"O" TIRES
 6985 MERIDIAN RD, PEYTON, CO 80831

SITE GRADING & EROSION CONTROL PLAN

Markup Summary

HORZ. SCALE: 1"=20'
 VERT. SCALE: N/A
 SURVEYED: RIDGELINE
 CREATED: 11/19/17
 PROJECT NO: 091701
 SHEET: C1.1

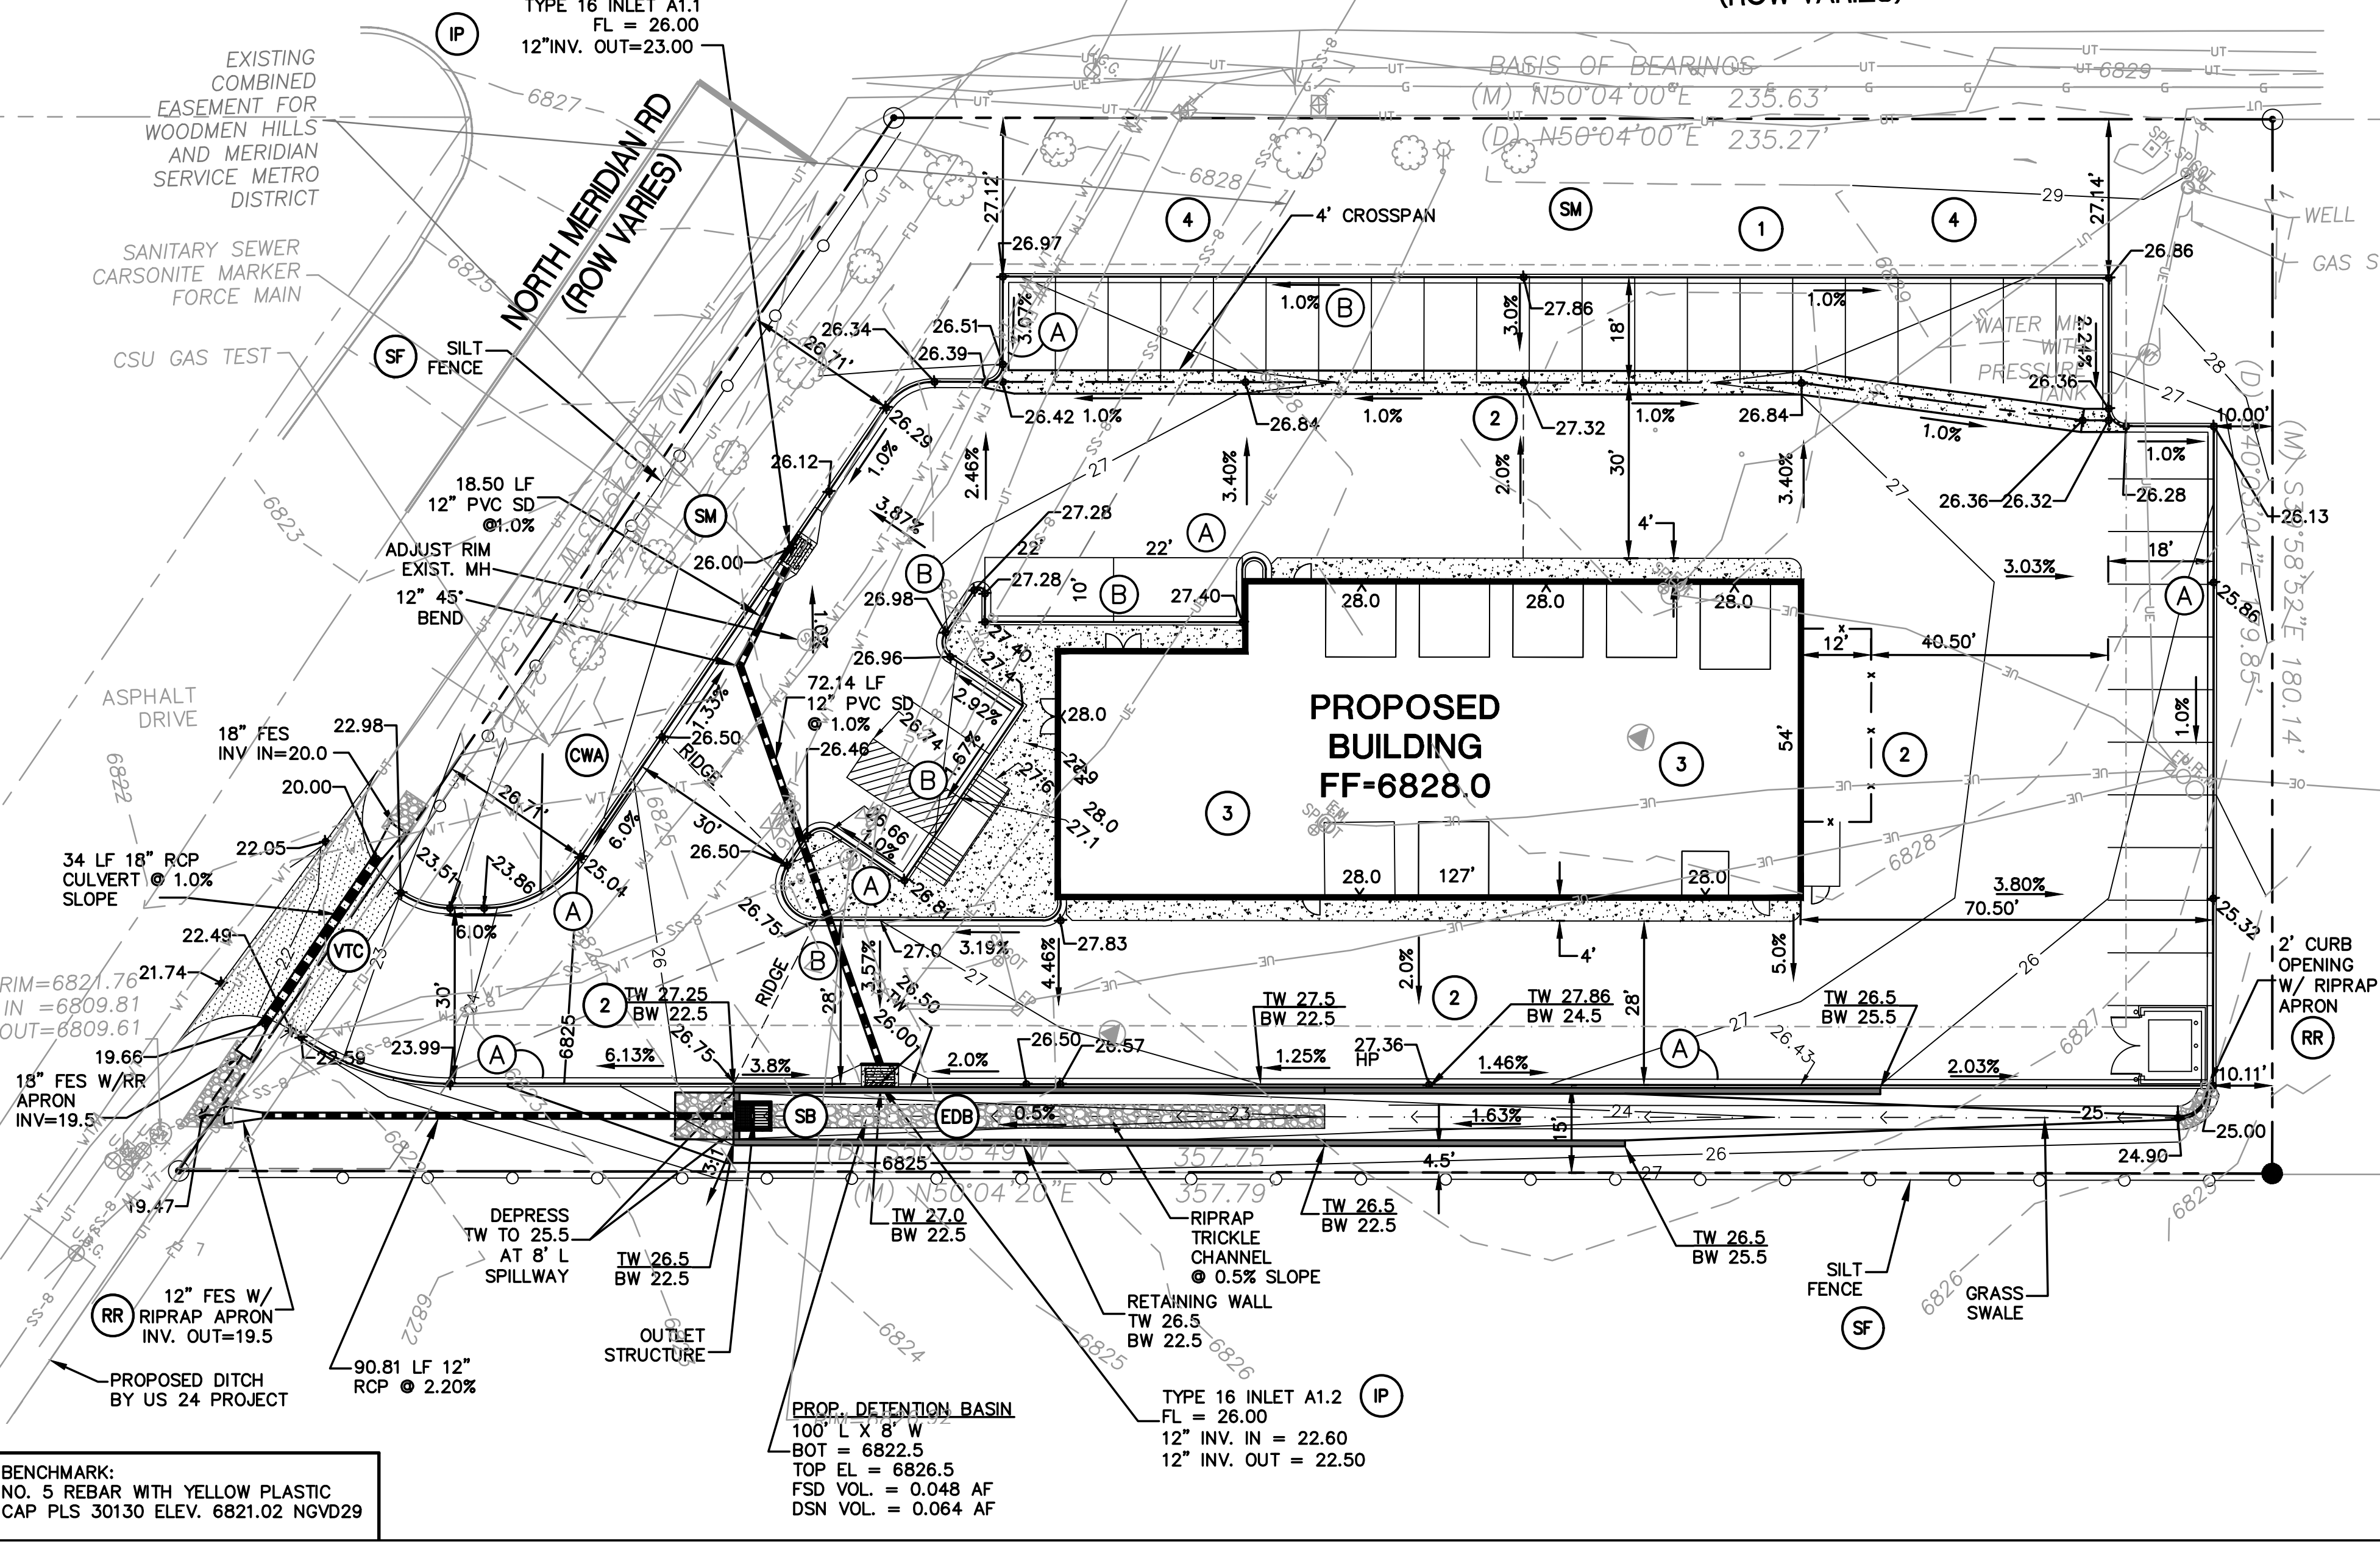
Provide a cross section showing how the inlet interfaces with the retaining wall.

Identify whether these are removed or protected in place

Per ECM 2.4.1.E, the driveway exceeds the maximum driveway width. Revise or submit a deviation request for consideration.

Provide the construction details.
 Identify the offset from the property line

Provide a low flow trickle channel in the EDB
